Project Name: 191 Marginal Way Redevelopment
Address: 191 Marginal Way, Portland, ME
Project ID: 2016-179
CBL: 24-C-21
Applicant: Earle W. Noyes & Sons
Planner: Nell Donaldson

On January 17, 2017, the Planning Authority approved with conditions a Level II site plan for the redevelopment of 191 Marginal Way. The decision is based upon the application as submitted by Stantec, Inc., with plan revisions dated December 16, 2016. The proposal was reviewed for conformance with the standards of the City of Portland's site plan ordinance, Article V of the land use code. The Level II site plan is approved with the following waivers and conditions:

191 Marginal Way - Final Traffic Comments

TO: Nell Donaldson, Planner
FROM: Lauren Swett, PE & Ghazal Kayal, EIT
DATE: January 6, 2017
RE: 191 Marginal Way Redevelopment, Level II Site Plan Application Response to Comments

DRAWING NUMBER  
**E1.00**

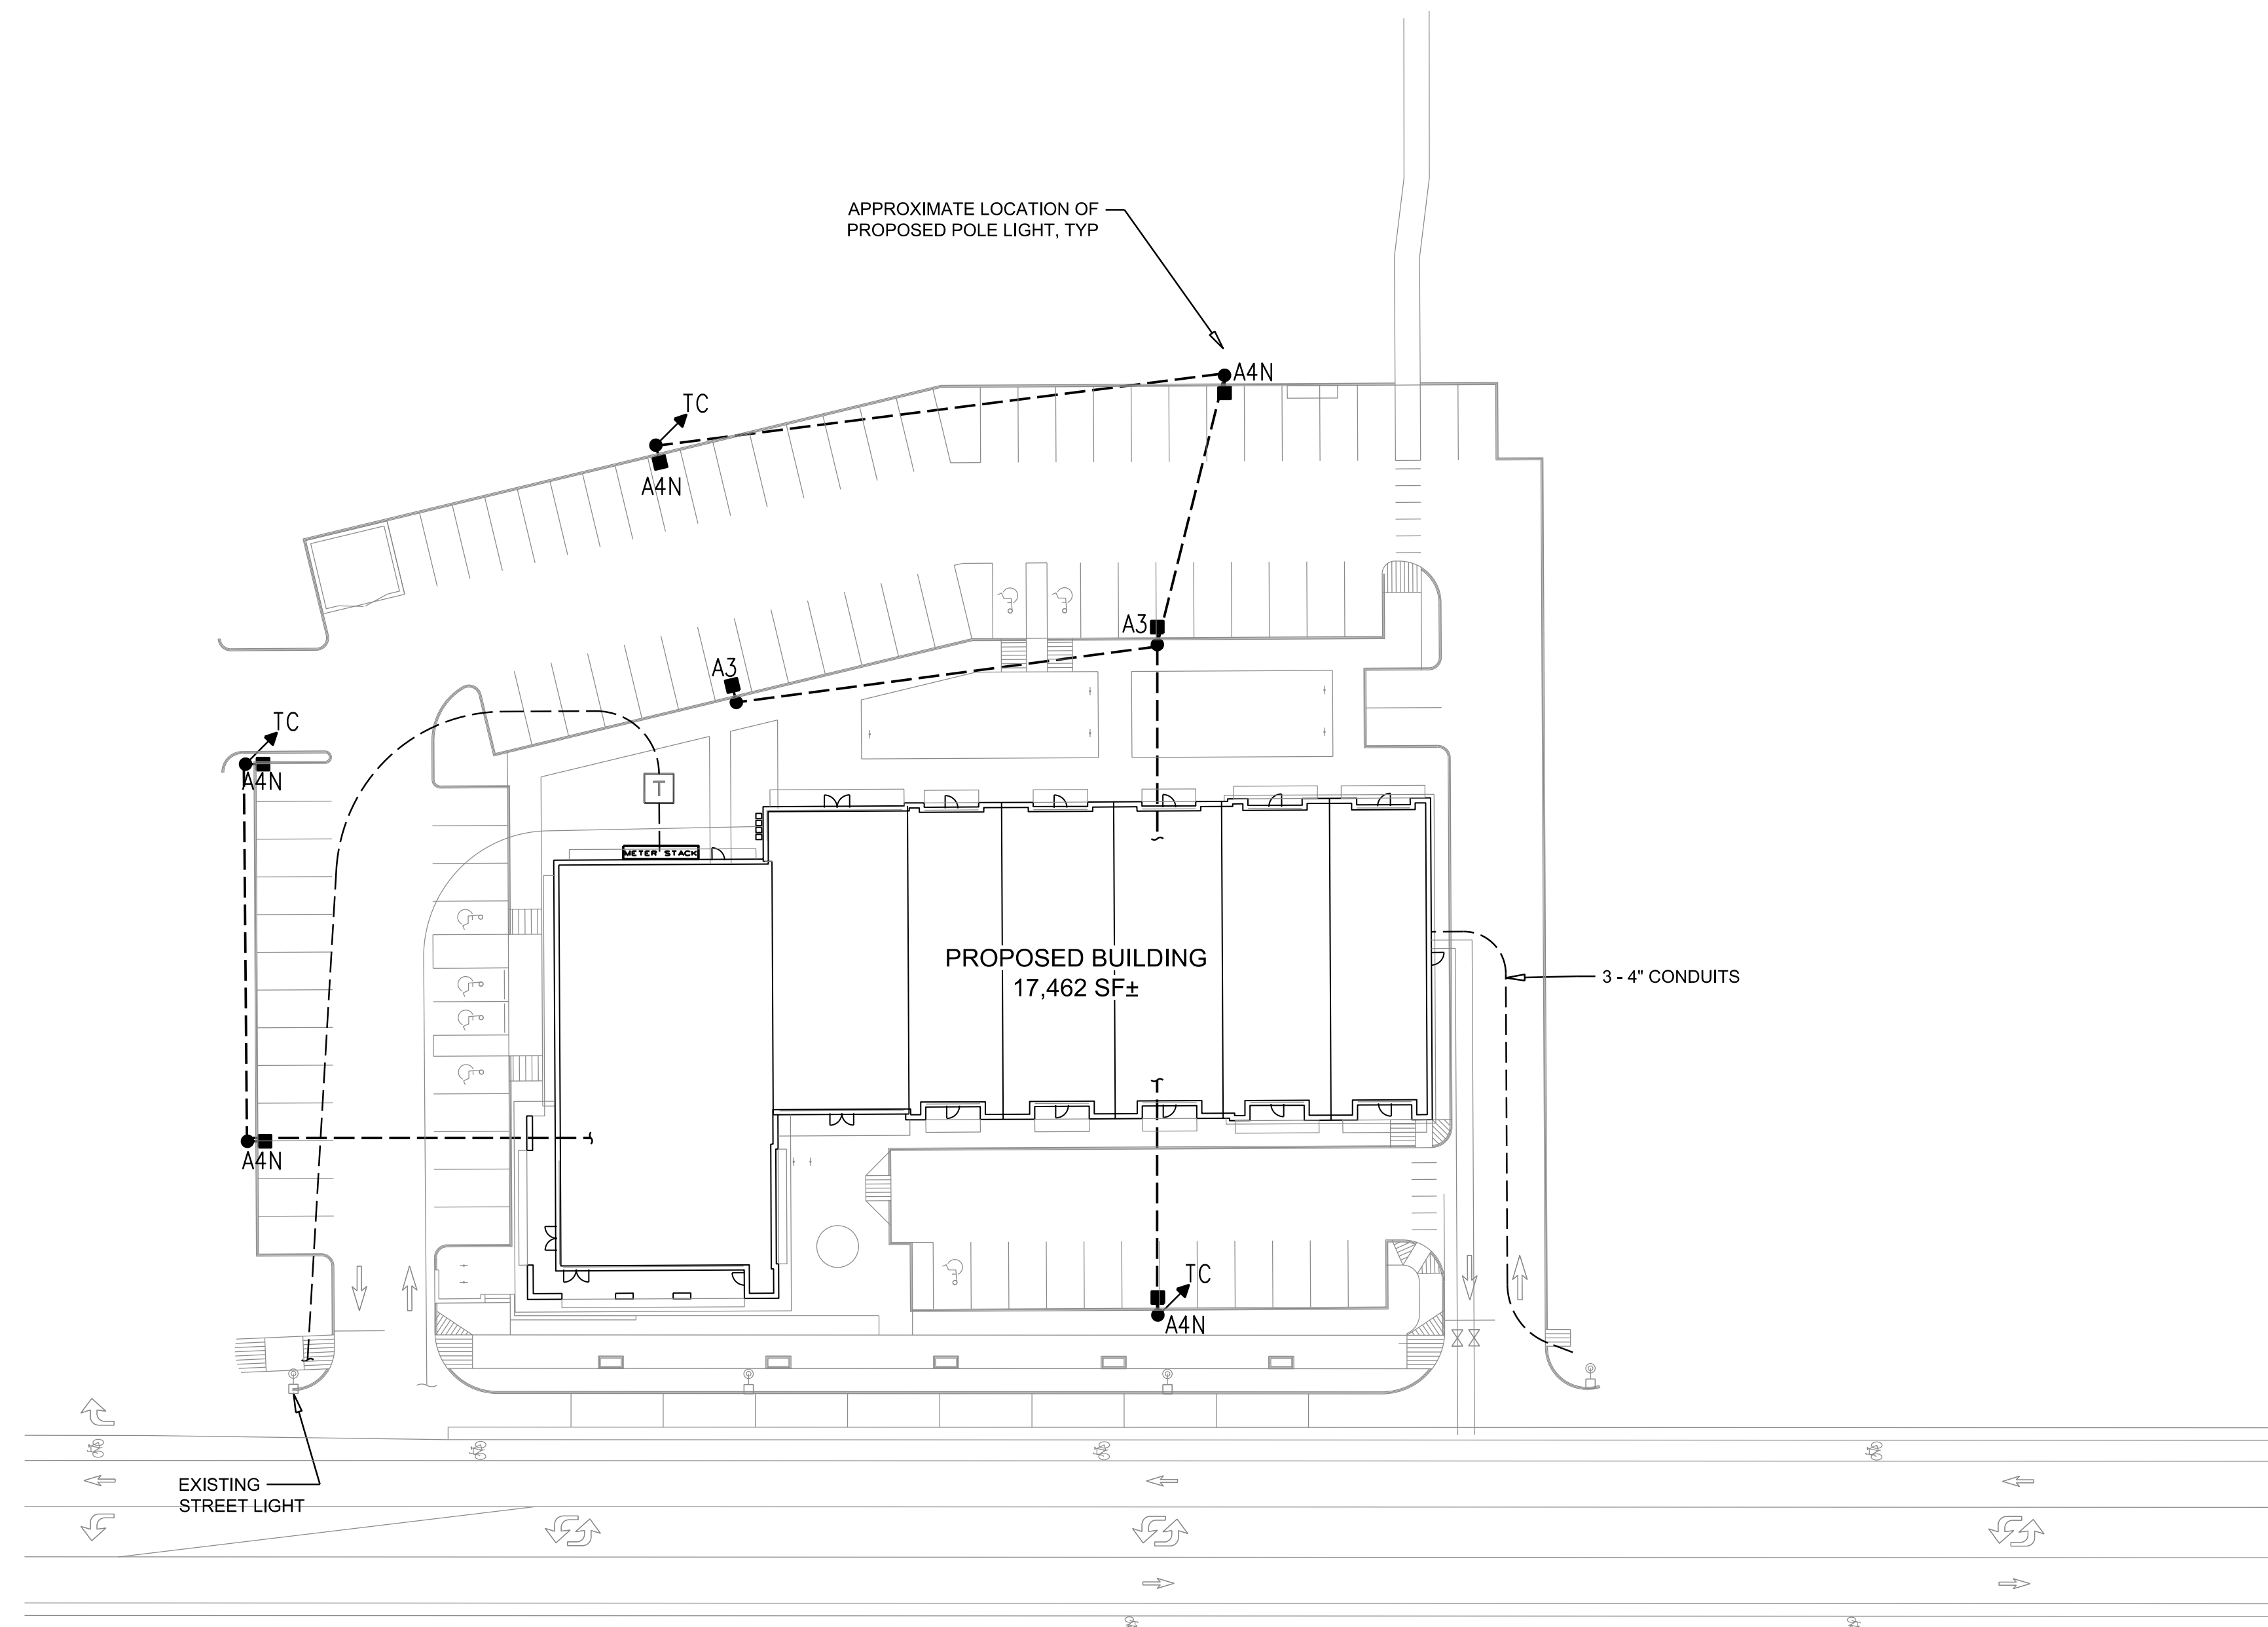
12. The applicant shall provide a revised lighting plan meeting maximum illumination levels of Technical Manual *Section 12* for review and approval by the Planning Authority;

191 MARGINAL WAY REDEVELOPMENT

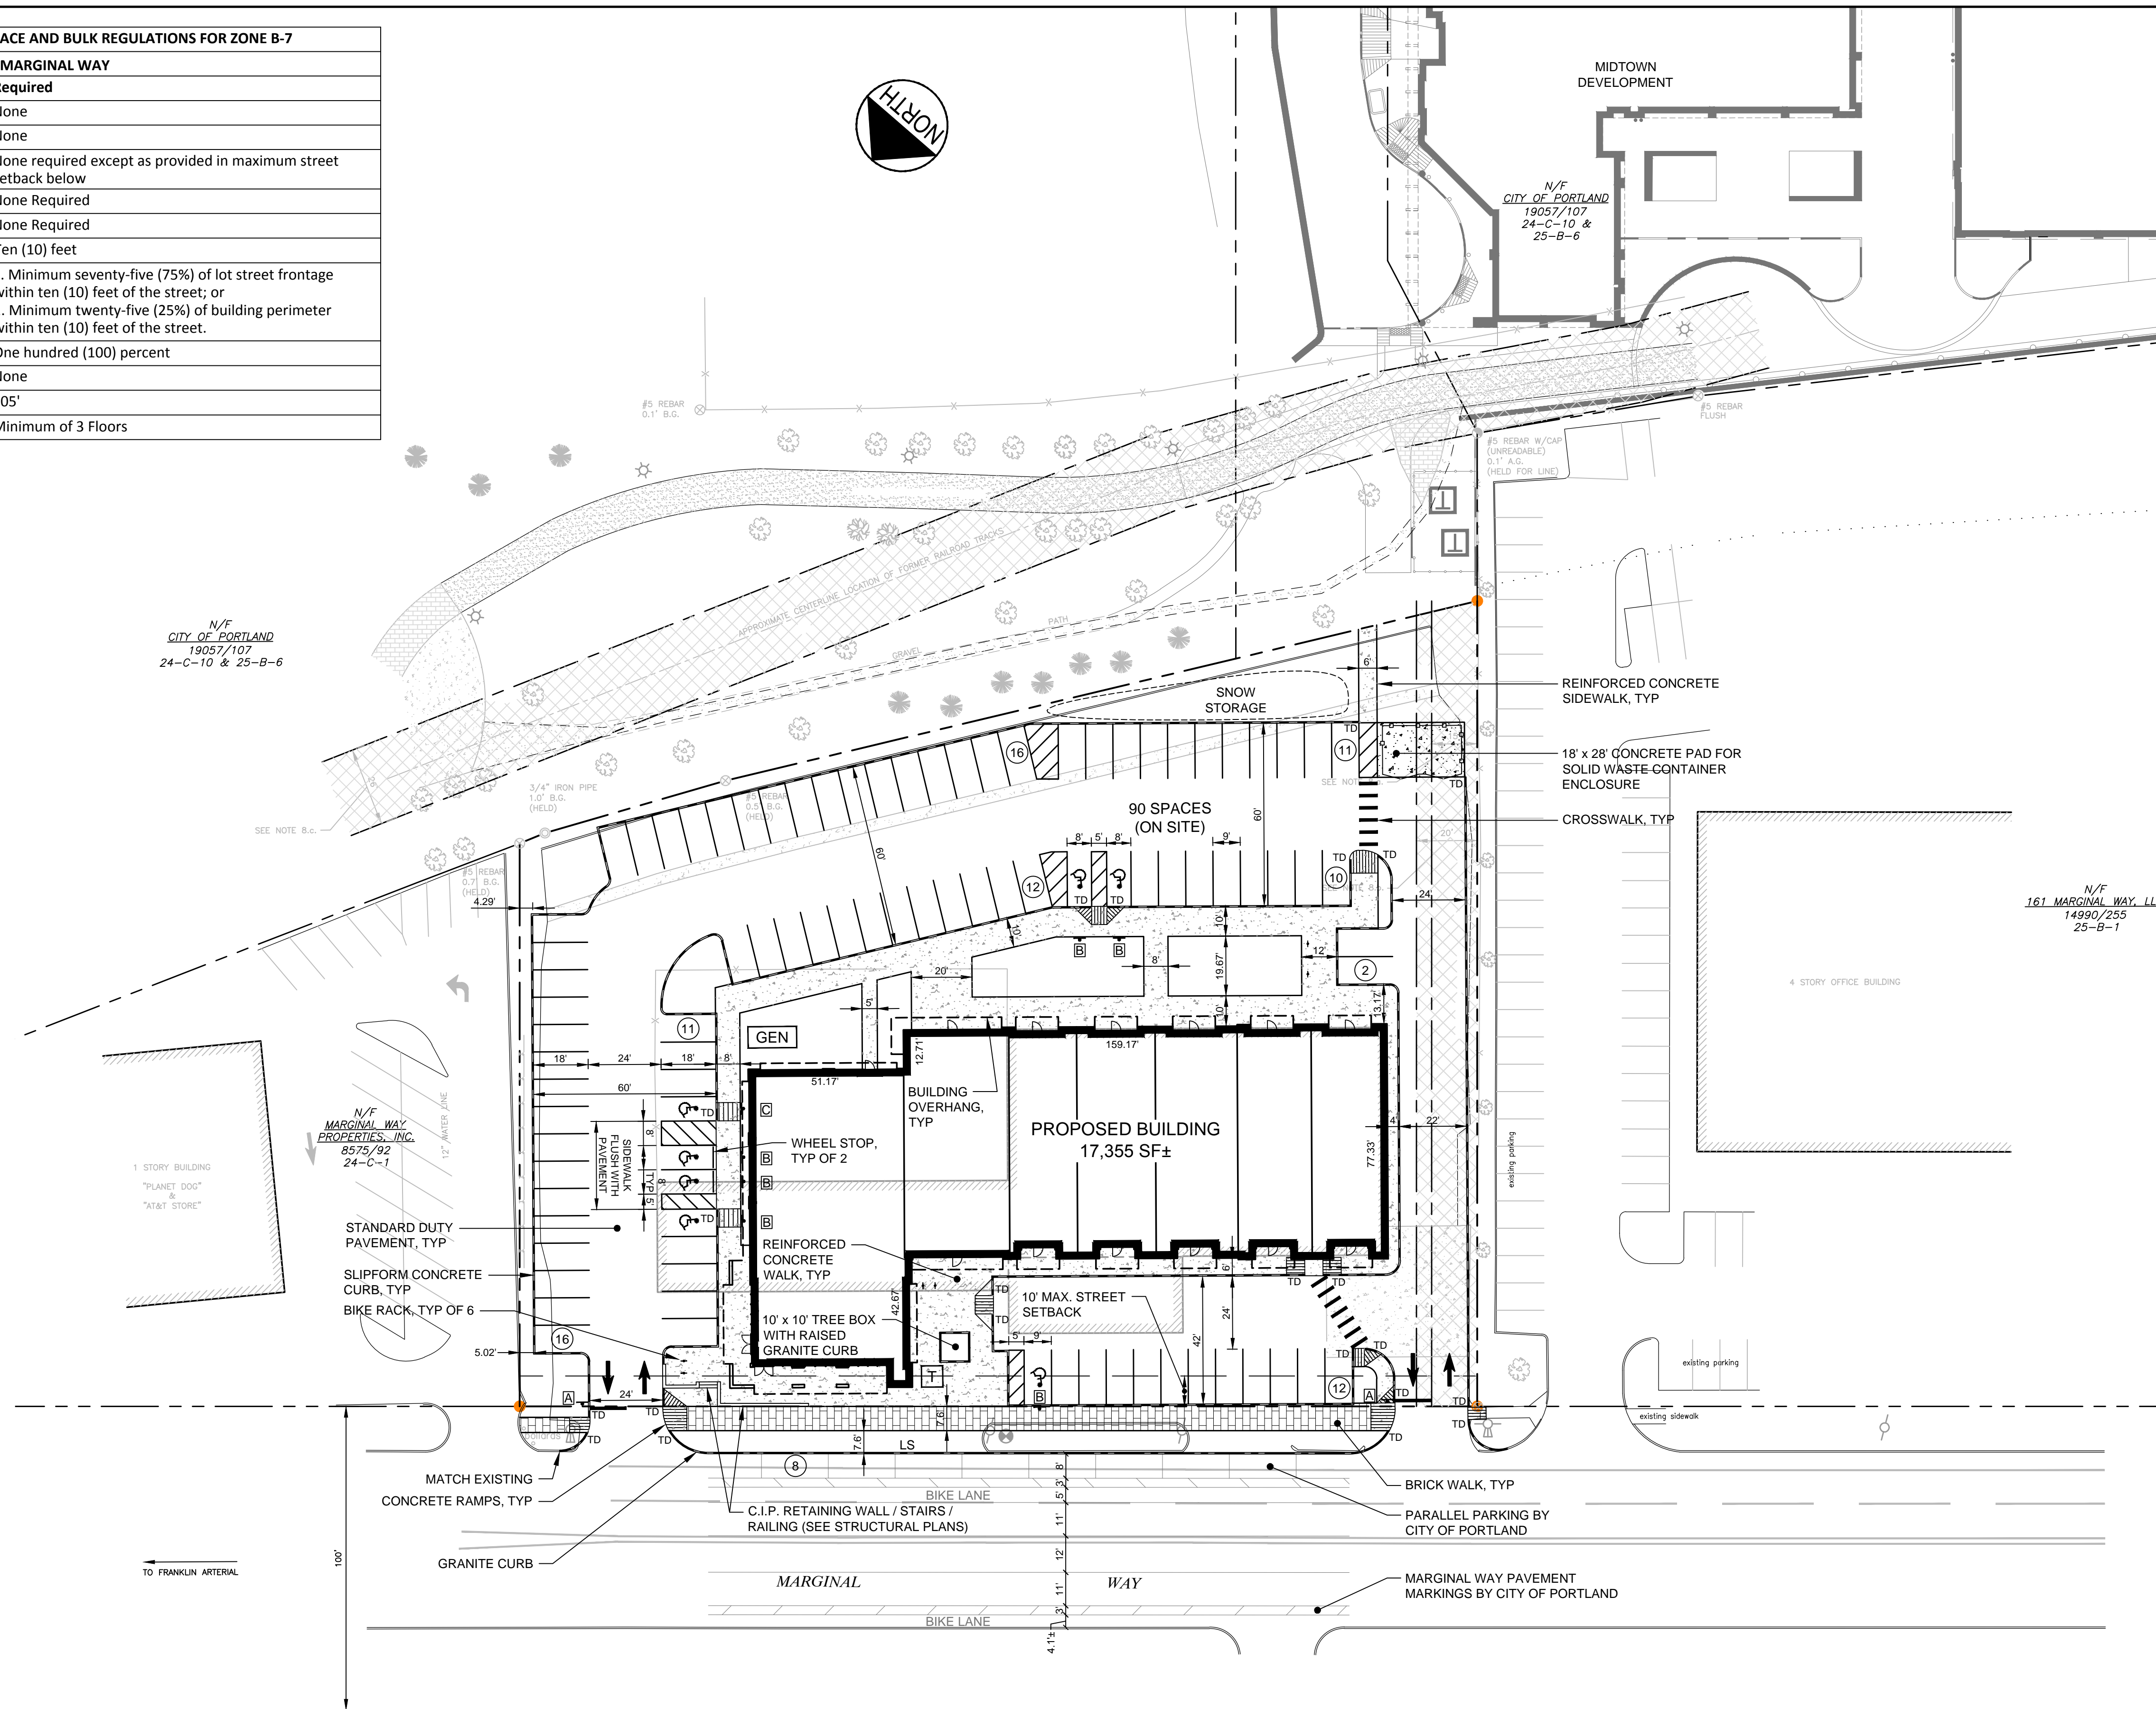
3. The applicant shall provide a revised pavement marking plan for review and approval by the Department of Public Works;
4. The applicant shall provide a construction management plan for review and approval by the Department of Public Works;

5. The applicant shall provide revised plans meeting ADA requirements for ramps and sidewalks for review and approval by the Department of Public Works;

6. The plans depict a sidewalk connection to the Bayside Trail that terminates at the rear property line. It is suggested that the applicant provide a complete connection to the trail.

- **There are a few sidewalk ramp locations that the applicant should review and modify such that they are fully accessible and ADA compliant. In general, these locations consist of ramp configurations where the ramp flare is located along the pedestrian travel route, thus creating an inaccessible route due to slope conditions. The locations for possible modification include:**
 - **The westerly driveway ramps into the site. All ramps from Marginal Way to the building corner.**

(A) EROSION CONTROL BLANKET DETAIL
N.T.S.

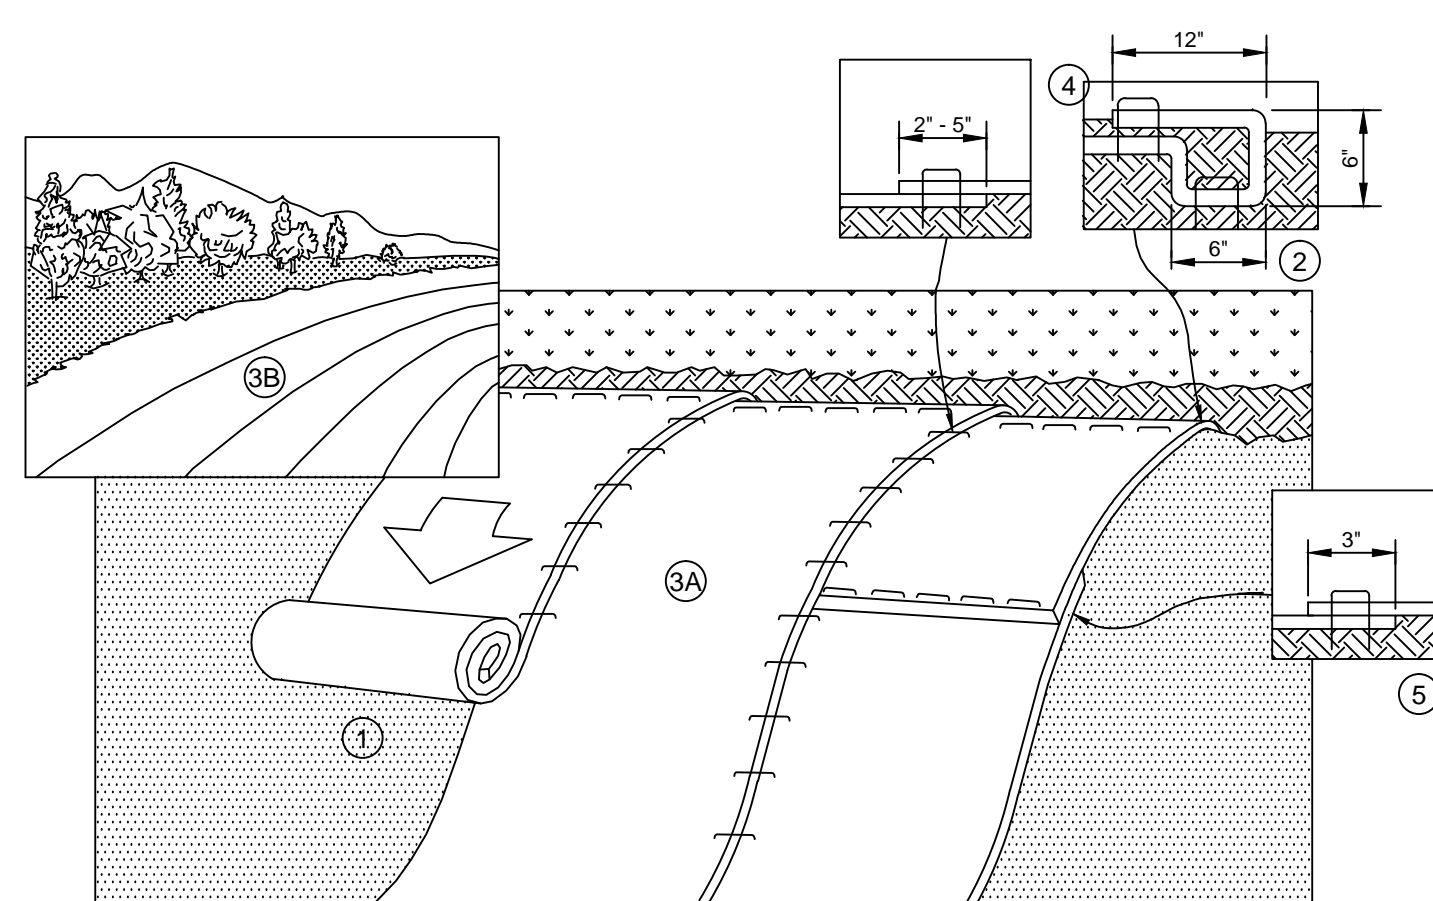
8. The applicant shall provide a revised grading plan noting that sediment barriers will be provided downgradient of all proposed work, particularly along the western side of the site adjacent to the abutting property for review and approval by the Department of Public Works;

- a) Basic Standard: Plans, notes, and details have been provided to address erosion and sediment control requirements, inspection and maintenance requirements, and good housekeeping practices in accordance with Appendix A, B, & C of MaineDEP Chapter 500. *However, sediment barriers should be provided downgradient of all proposed work, particularly along the western side of the Site adjacent to the abutting property.*
